**Environment Agency Representation for Southampton to London Pipeline Project (EN070005)**

**Our ref:** HA/2019/121344/03  
**Your ref:** 20022740

**Application by Esso Petroleum Company Limited for an Order Granting Development Consent for the Southampton to London Pipeline Project**

## Appendix A

Cove Brook Flood Storage Area (Work Plan 33 and 34 - Grid Ref 485434, 155440)

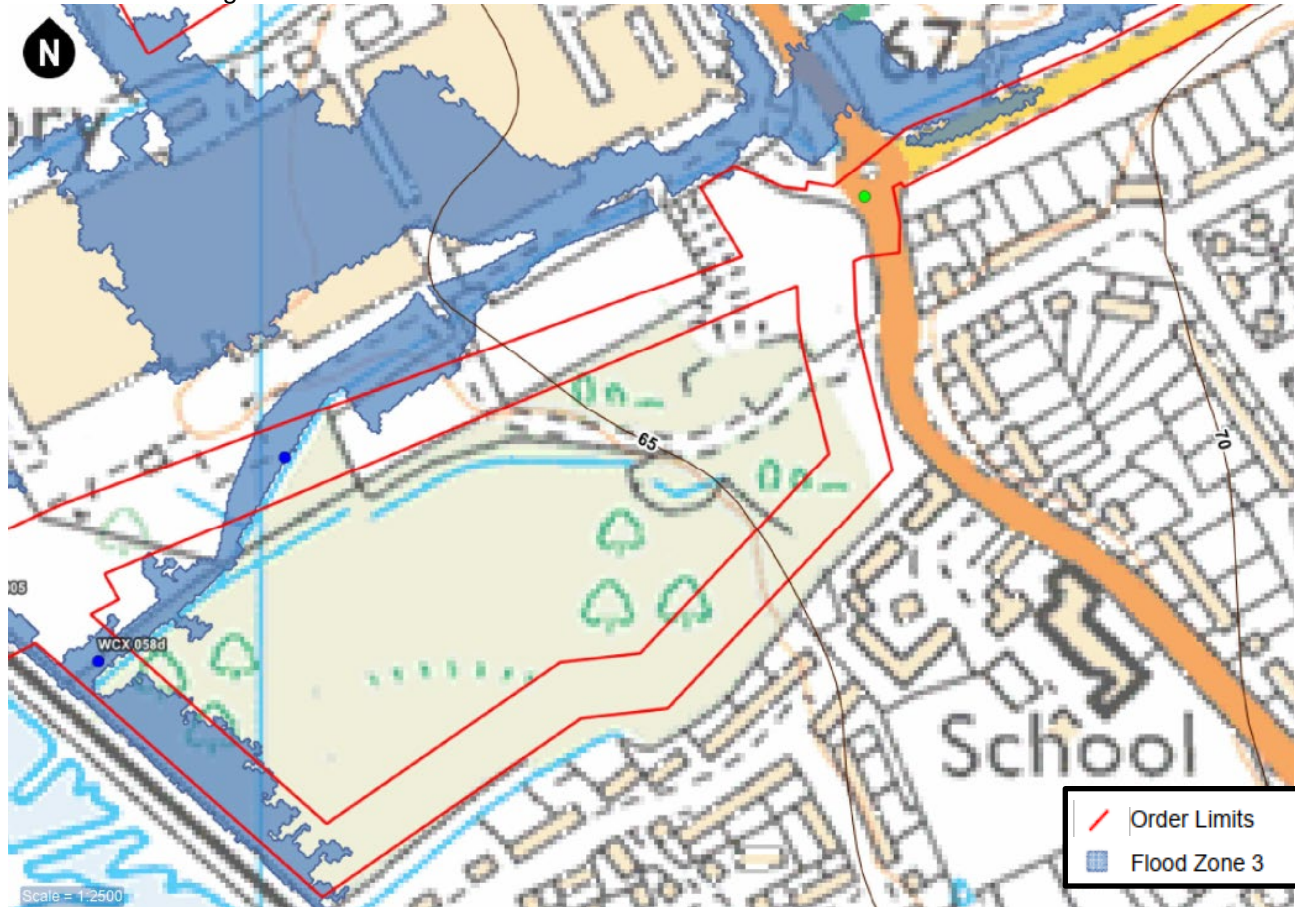
### **4.0 Cove Brook Flood Storage Area**

4.1 At our meeting with Jacobs on 19 September, Steve Newman of Jacobs confirmed that the applicant now proposes to use a trenchless crossing technique for the Cove Brook Flood Storage Area (FSA). This was subsequently confirmed in the draft minutes of the meeting, which we received on 11 October, and agreed as final on 12 November. Our preference is for a trenchless crossing of the FSA in order to avoid impacts on the embankment structure.

4.3 We have previously advised the applicant that the depth of any trenchless crossing must be sufficient to allow us to strengthen or replace the FSA embankment in future, noting that any future foundations may be deeper than the current structure. We have been assured by the applicant that there is sufficient room within the current red-line boundary of the scheme to achieve sufficient depth.

4.4 One new issue that has emerged is within TN1 (Works within Flood Zone 3), paragraph 1.2.7, which suggests that material could be stockpiled within the FSA. We have previously advised the applicant through our pre-application engagement that it would be unacceptable to store material for any length of time within the operational FSA (unless appropriate mitigation and/or compensation was provided for such storage).
